Re: Comment Response to City of Portland Peer Review Engineer

On behalf of the project team Acorn Engineering, Inc. is pleased to respond to the comments provided by the City Peer Review Engineer dated July 15<sup>th</sup>, 2011 by David Senus, P.E. and Ashley Auger, E.I.T. of Woodward & Curran.

1 RECONSTRUCTED BRICK DRIVEWAY APRON LAYOUT  
NOT TO SCALE  
L3.0

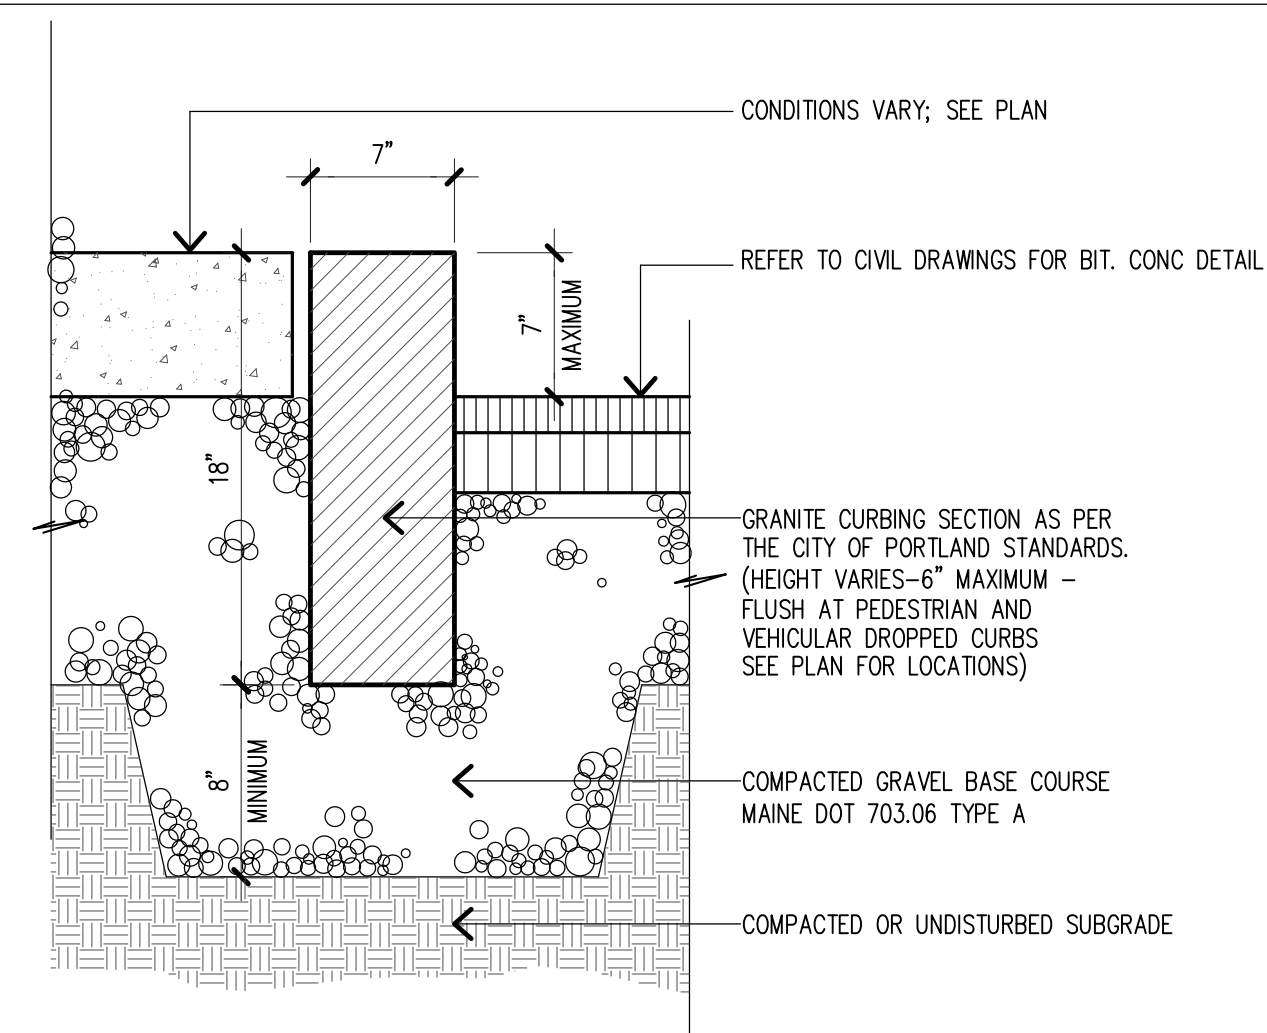
*14. The proposed driveway entrance is shown on the plans with radial curbing. The detail provided on sheet L3.0 for the Reconstructed Brick Driveway Apron Layout does not indicate the use of radial curbing. The applicant should clarify the type of curbing and modify the plans or detail to reflect the correct curbing layout.*

**Response:** The proposed driveway entrance shown on the plans has been updated to reflect the what is shown within Soren Deniords Design Studio's revised Sheet L3.0 - Reconstructed Brick Driveway Apron Layout (Detail 2). Per the City of Portland's Technical Standards Manual – Driveway Apron Layout (I-9) the proposed driveway apron layout does not include curbing. The landscaped island will include vertical curbing per Sheet L.3.0 – Granite Curbing (Detail 7). A 5 ft radius is proposed around the landscaped island.
